# ENG-PUDSP21005-R3-PUDSP.pdf Markup Summary

**Subject:** Callout  
**Page Index:** 1  
**Date:** 4/15/2022 3:10:03 PM  
**Author:** Ryan Howser  
**Color:** ■  
**Layer:**  
**Space:**  
**Page Label:** [1] WB PUDSP 3.10.22-Cover

SHEET TITLE:  
**PLANTING  
PLAN  
SAYBROOK**

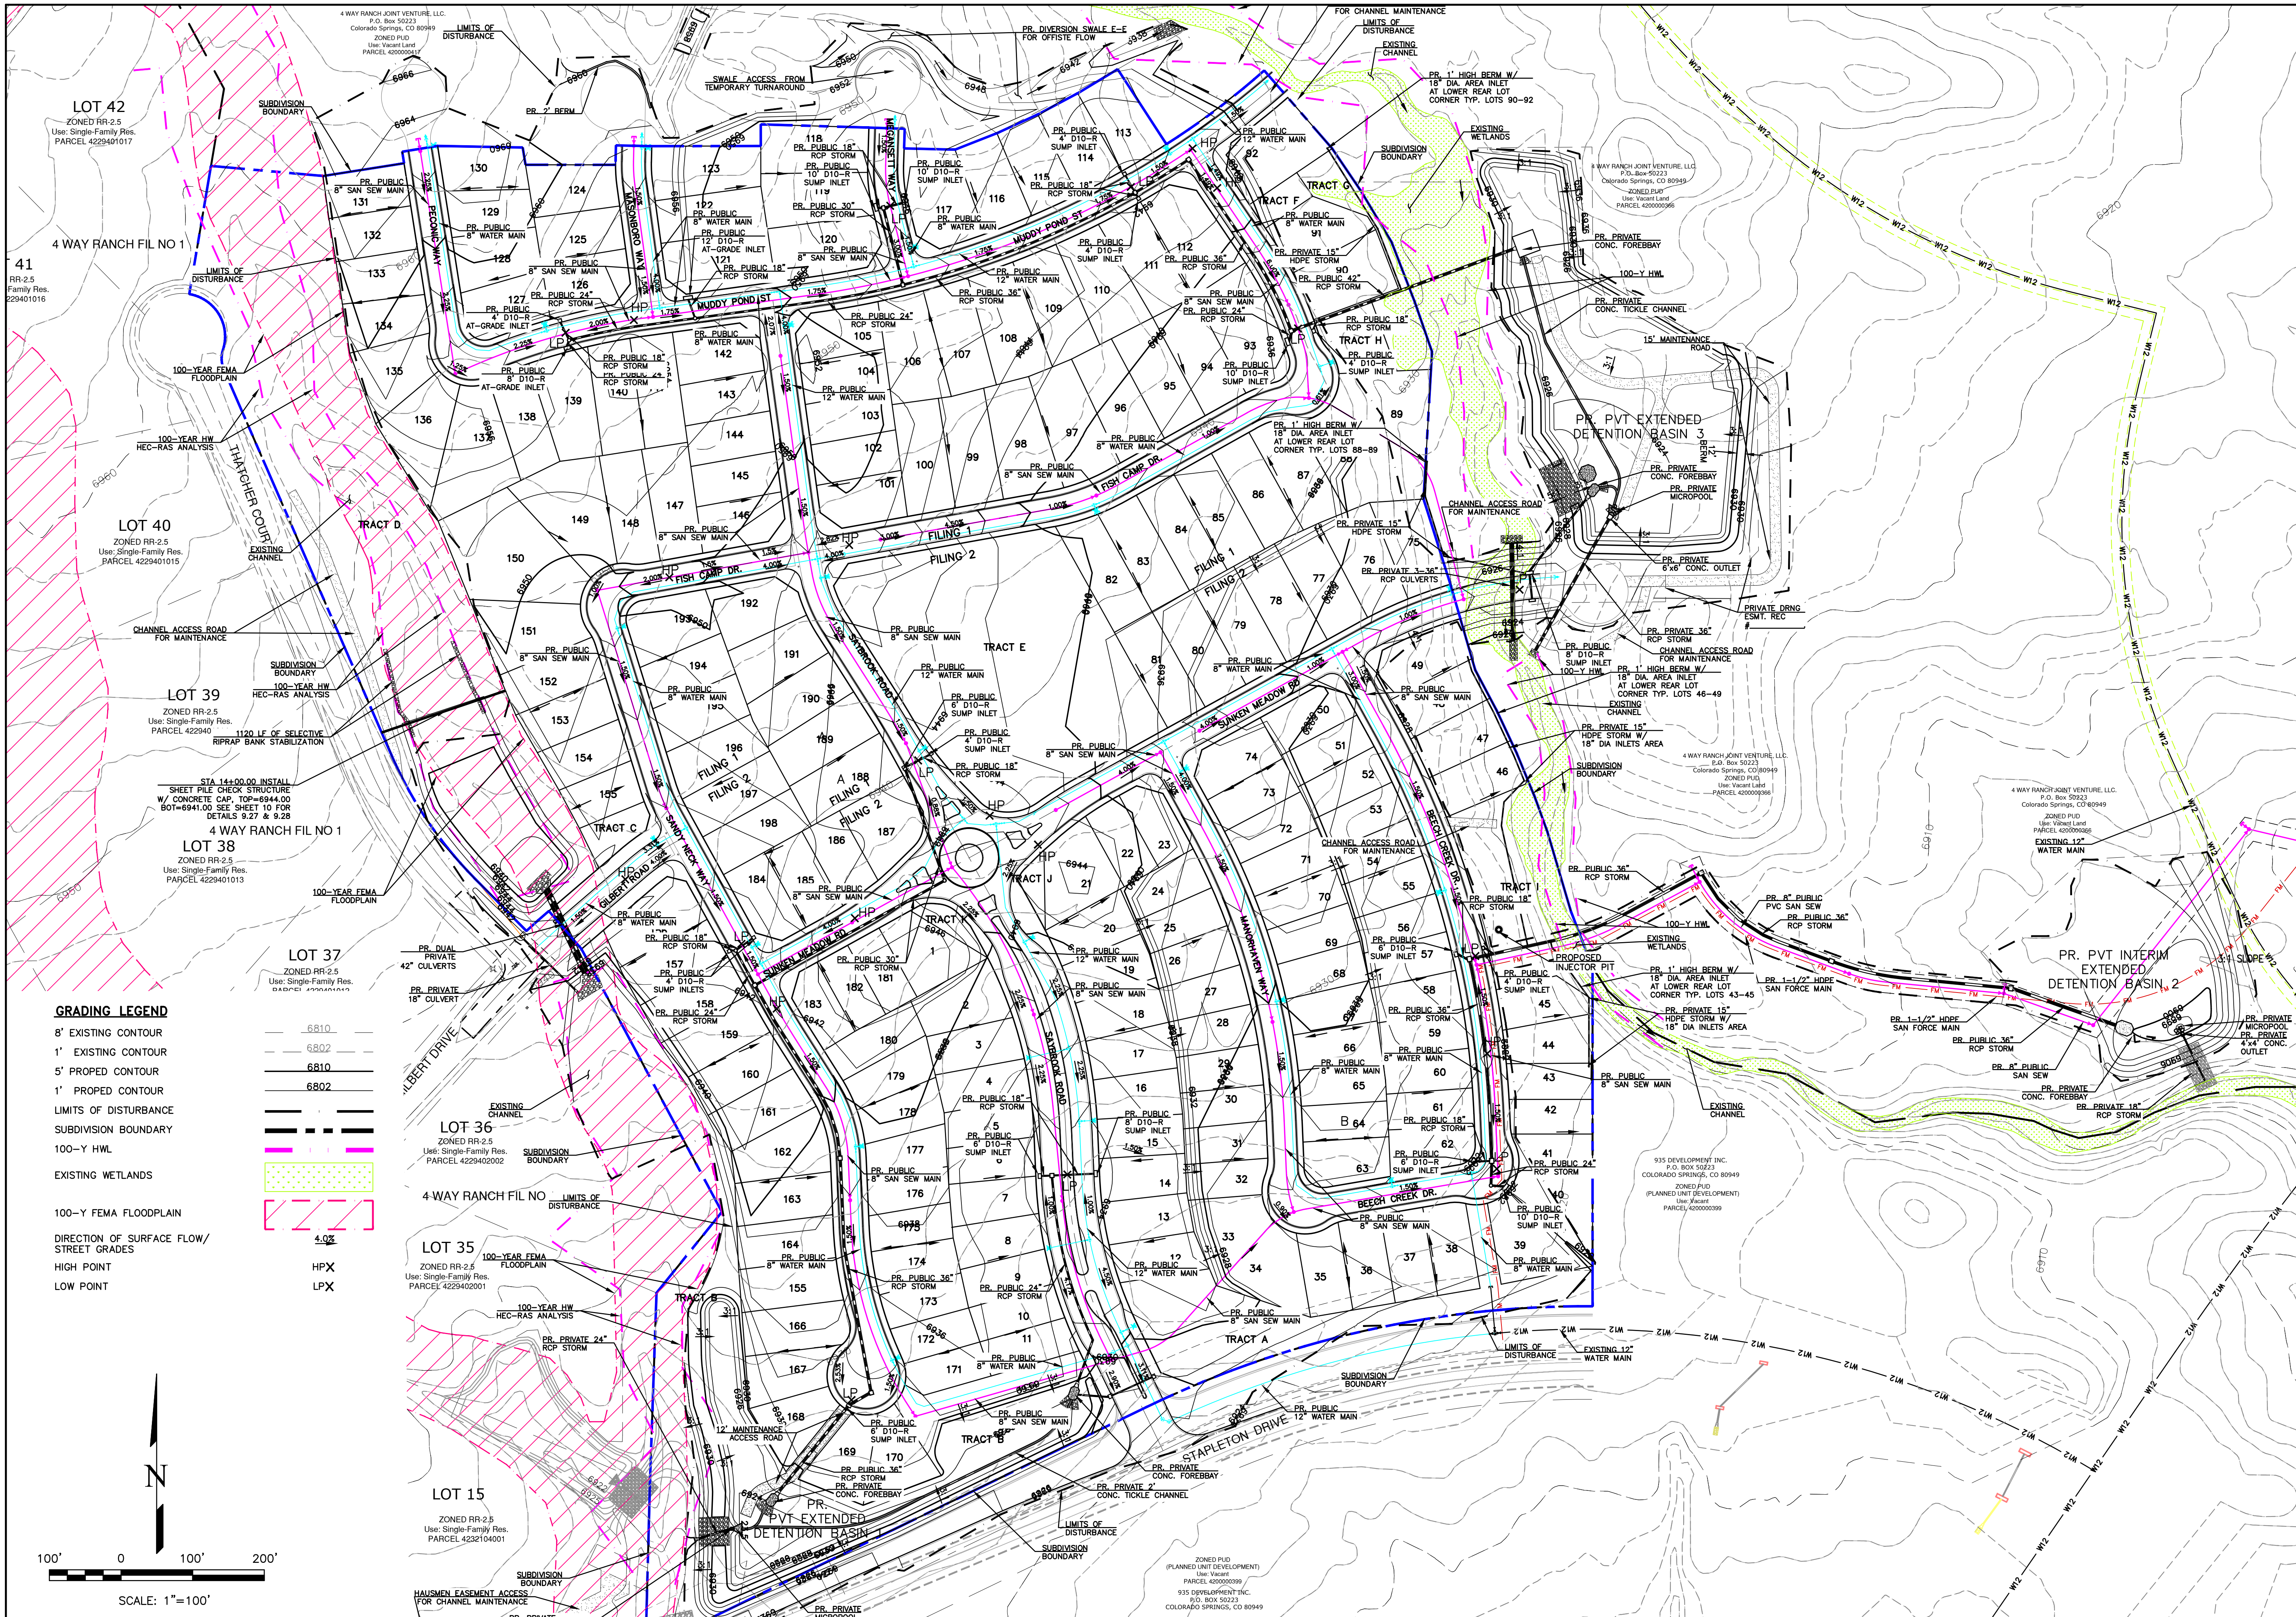
Add a note stating that roundabout lighting, landscaping and grading will be finalized with CDs

SHEET TITLE: WEST AREA DEVELOPMENT PLAN

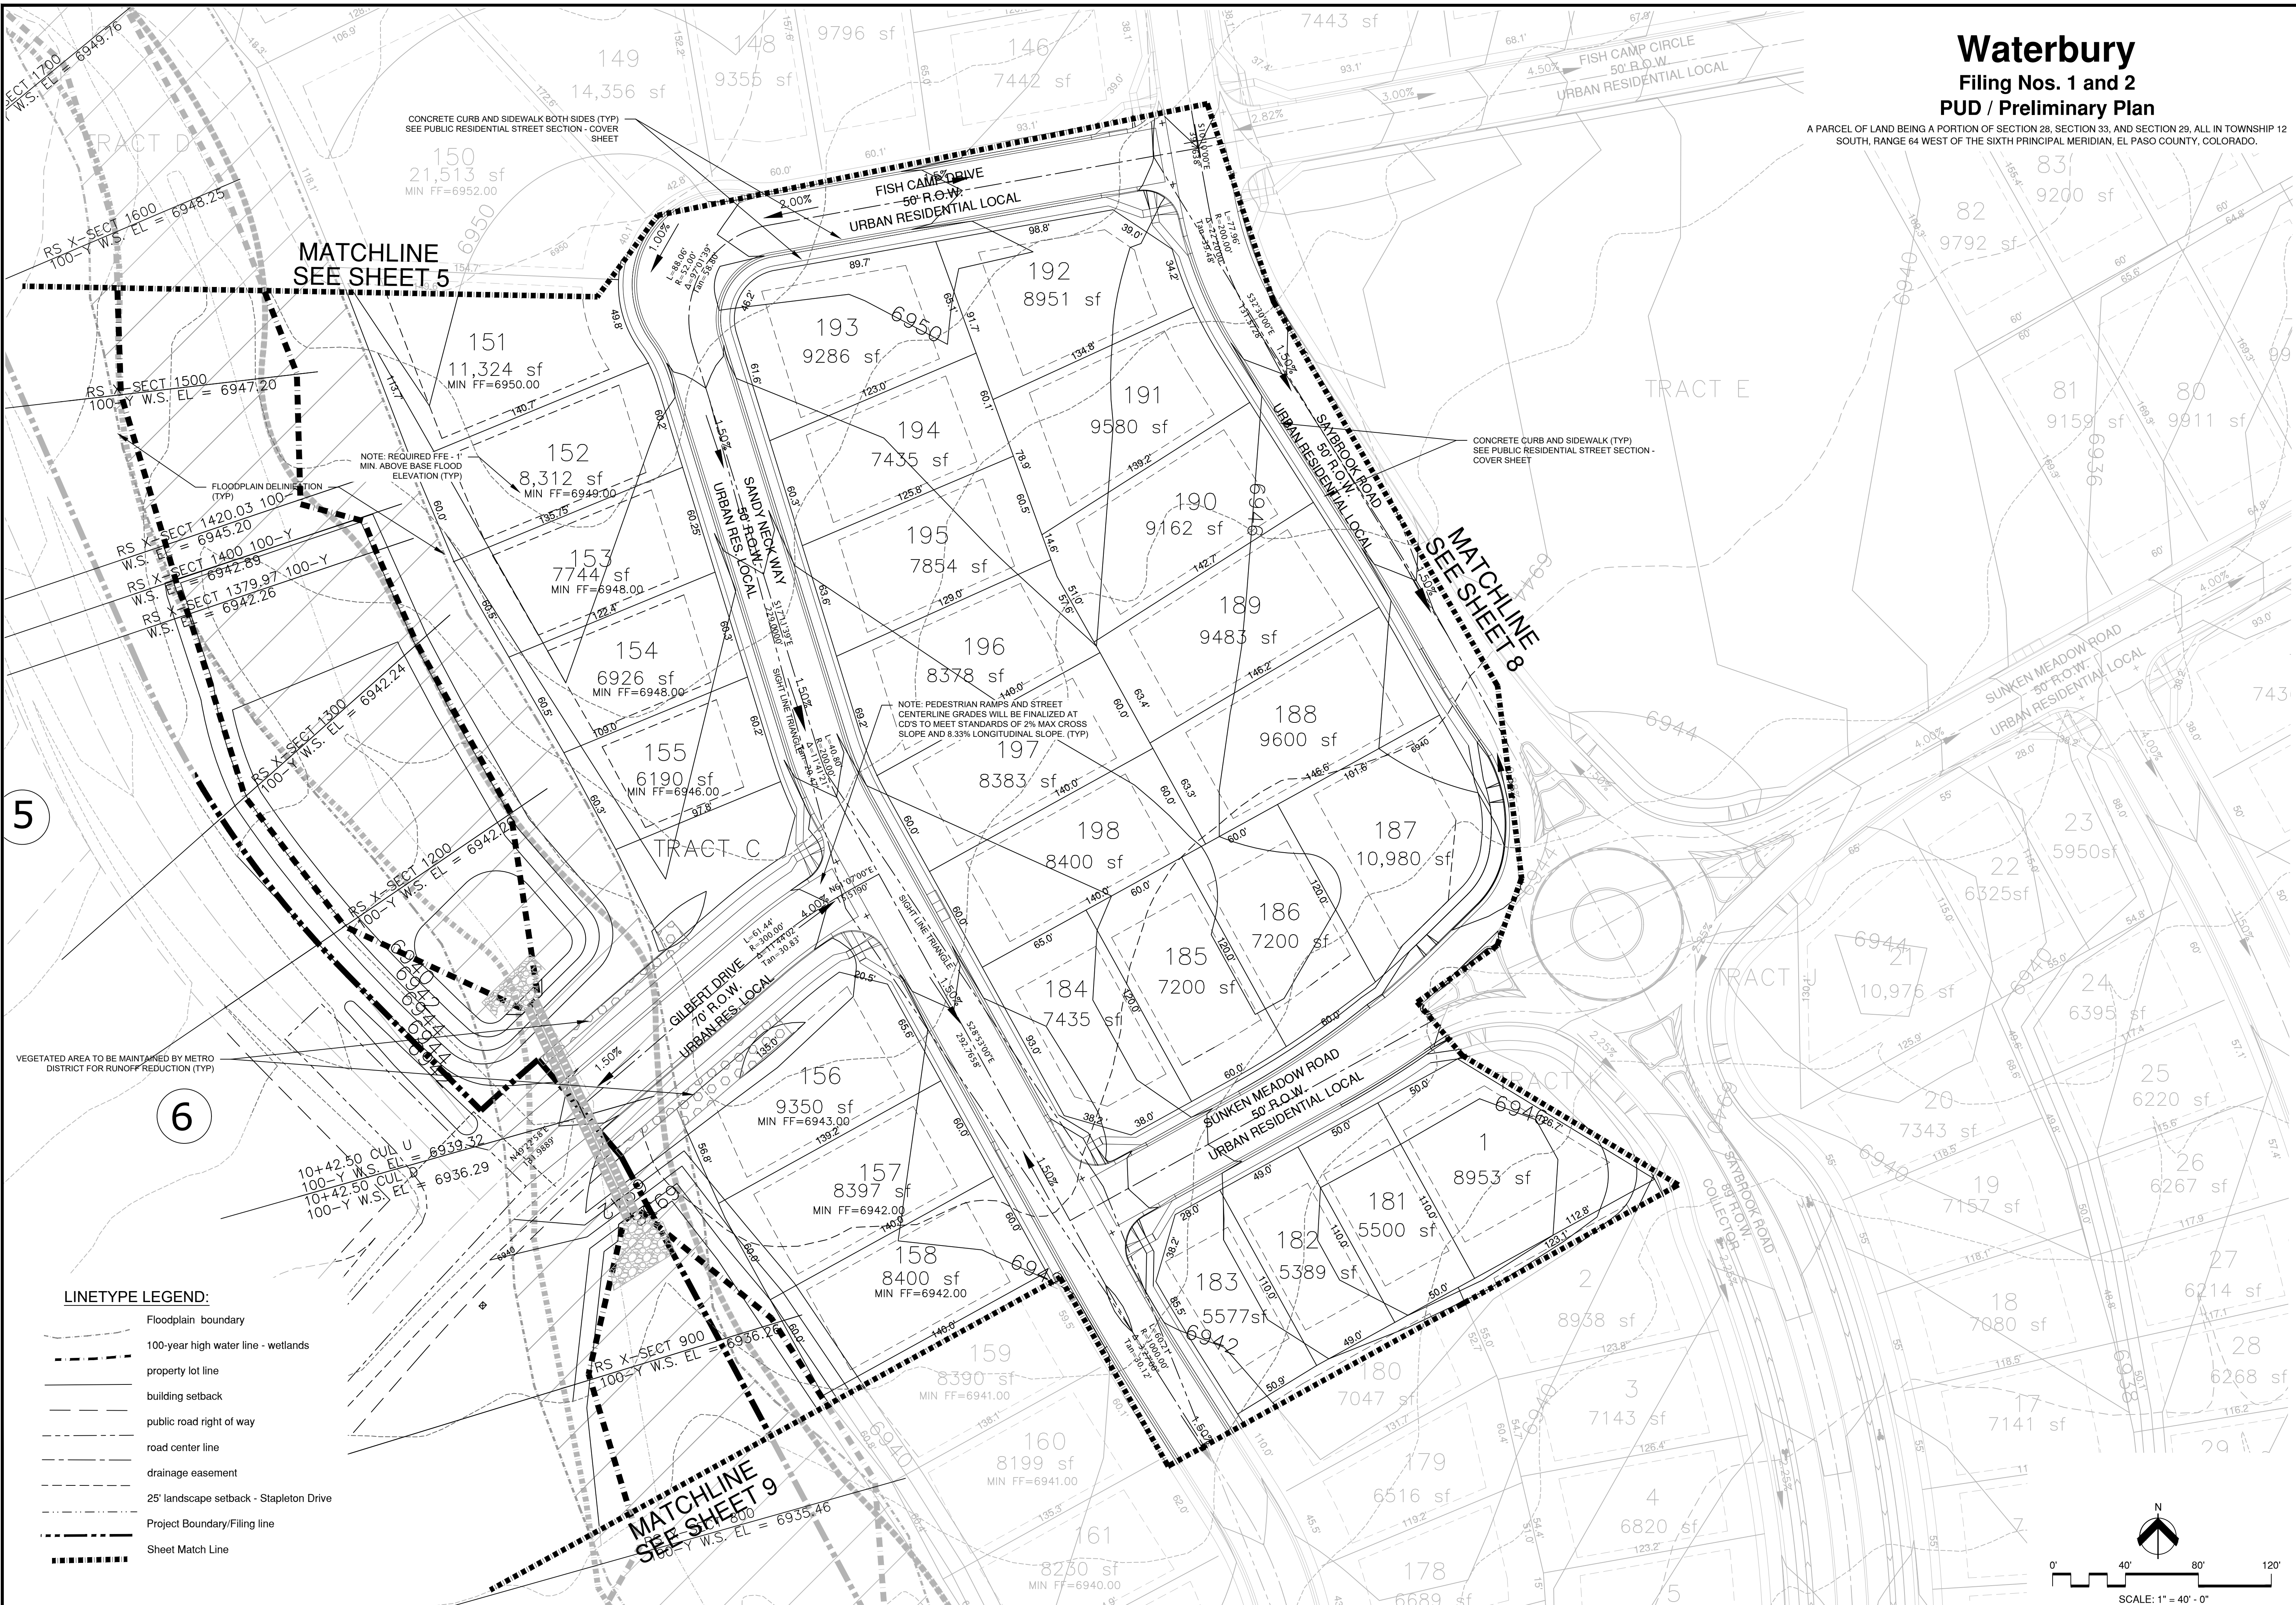
Line needs to extend to ROW

Fix overlapping text

**SHEET TITLE:**  
EAST AREA DEVELOPMENT PLAN

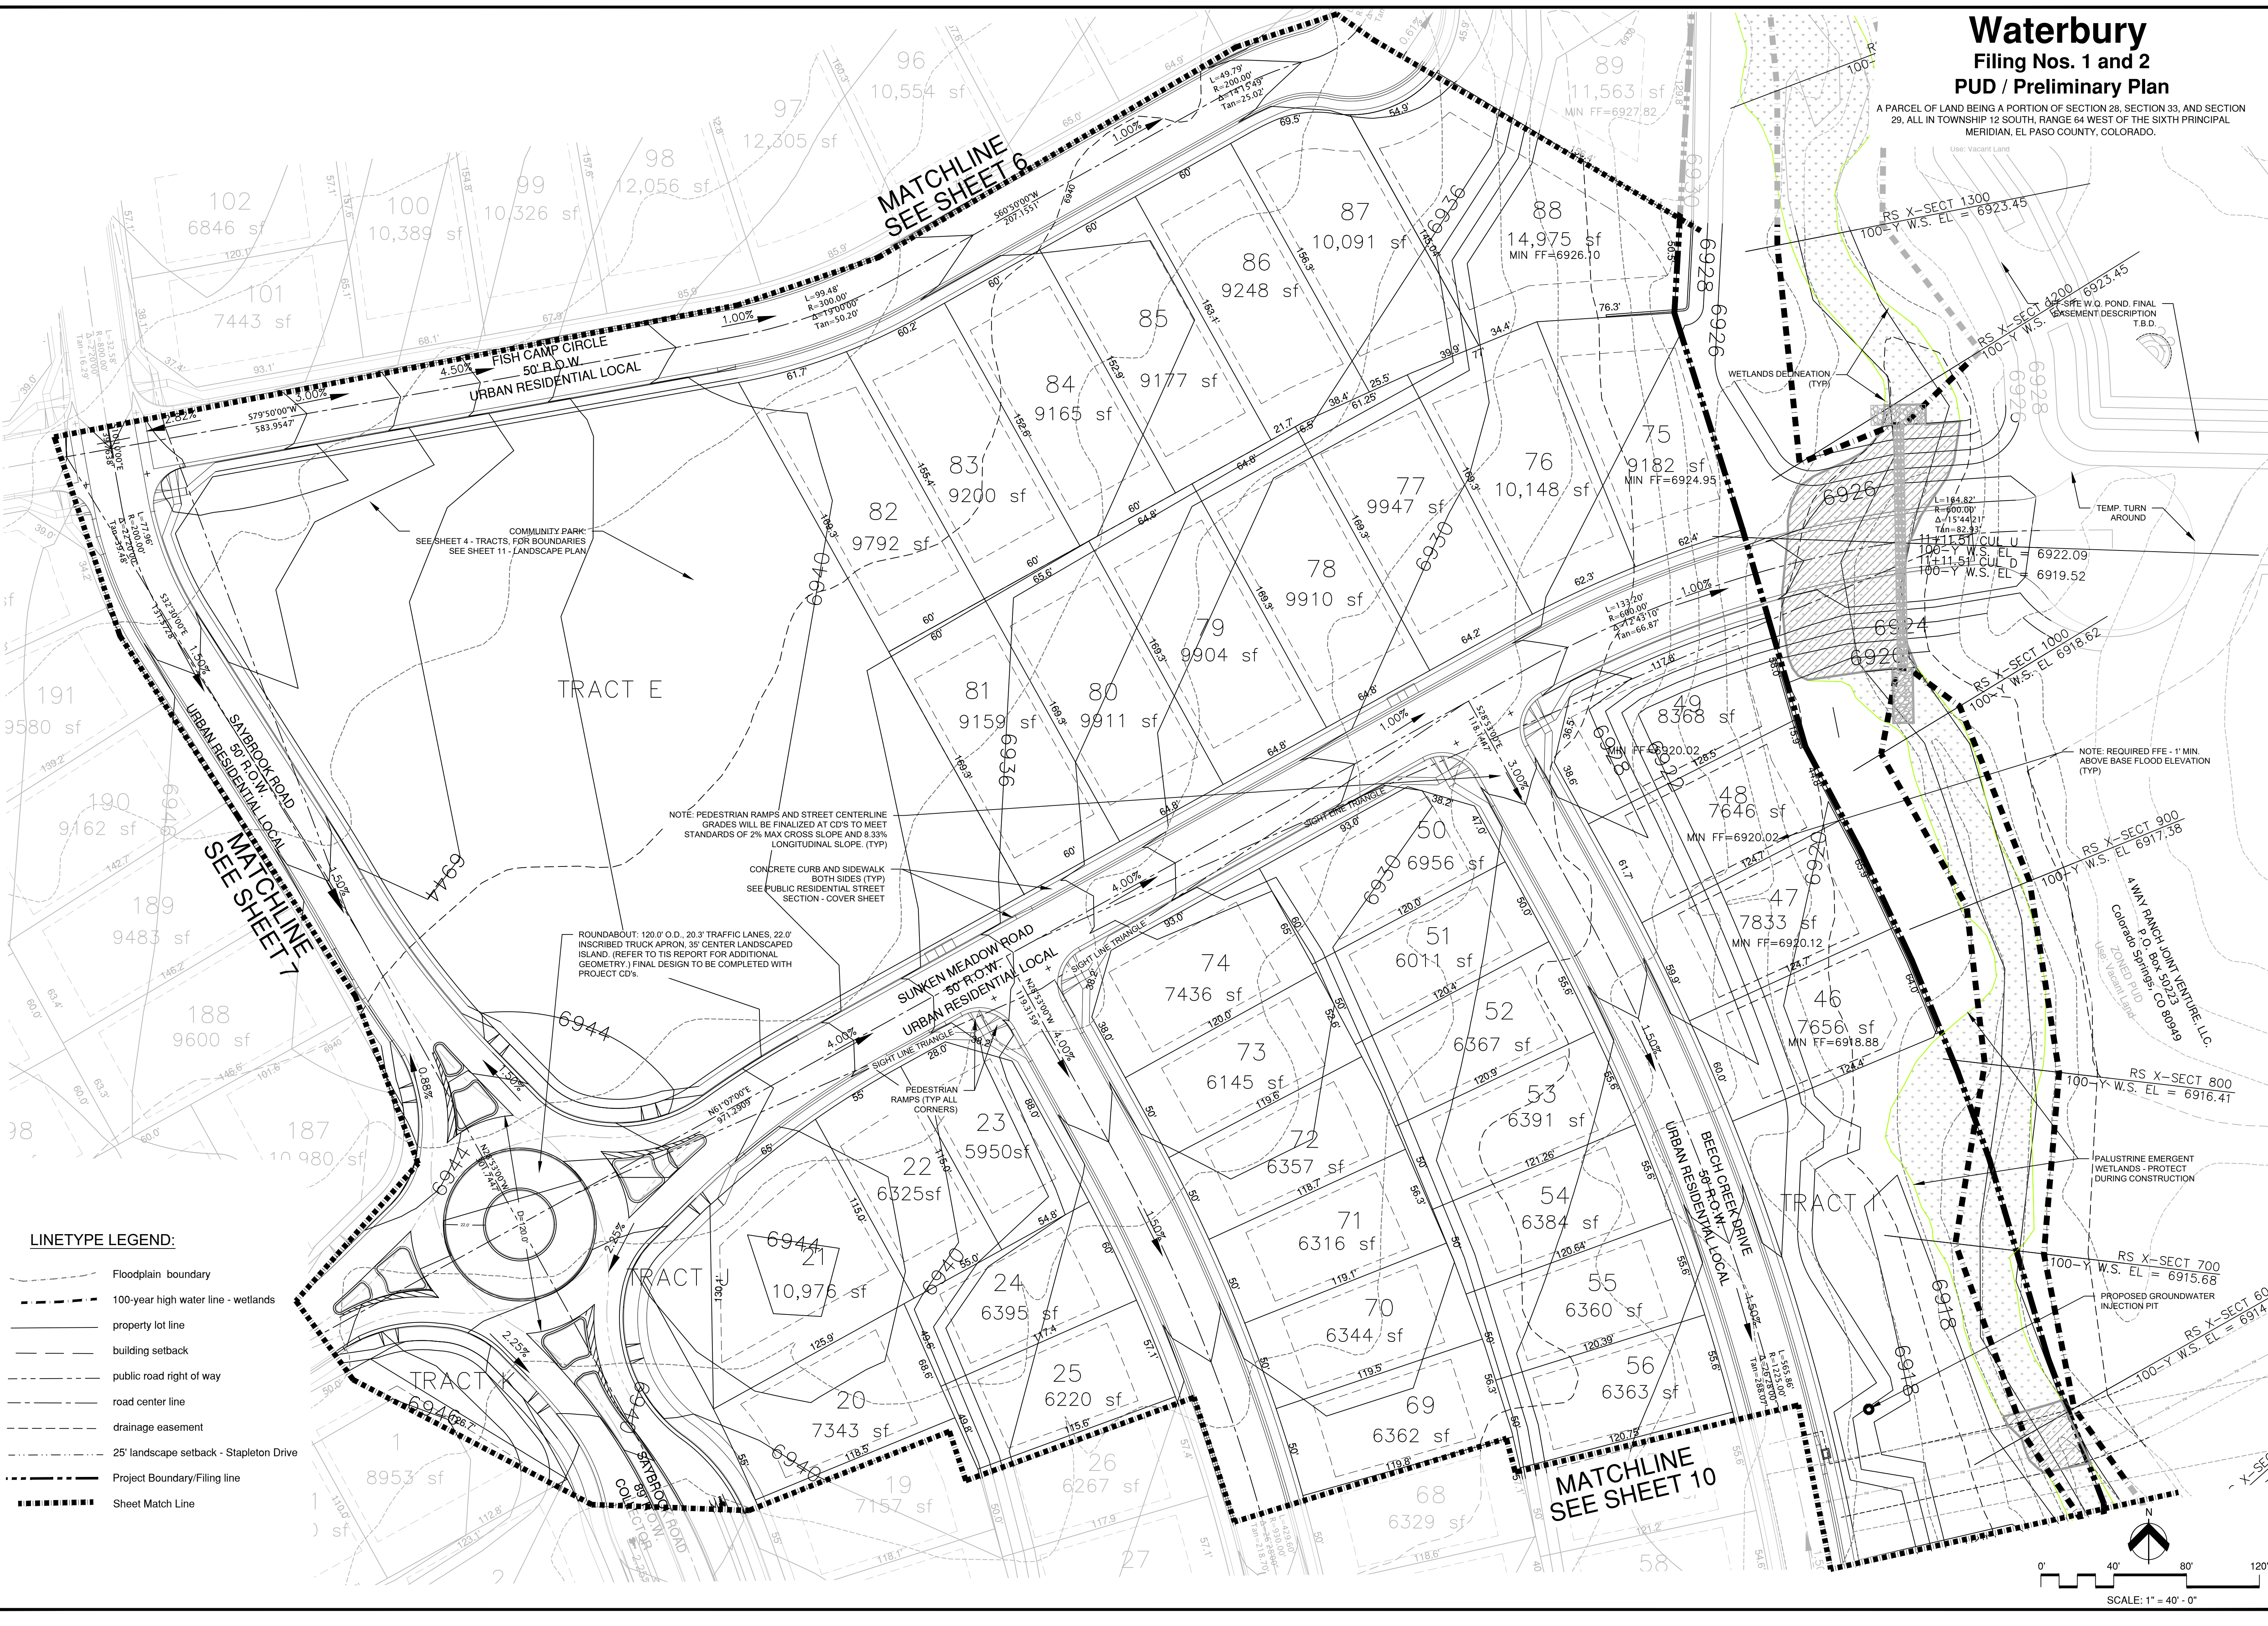
Missing sight triangle lines

Can't read all of note

Label temporary turnaround

Add note describing size of roundabout (XX' inscribed circle with XX center island and truck apron all based on TIS RAB revisions), final design TBD with CDs. Revise the layout per the TIS.

Label tract boundary distances and SF (all tracts)
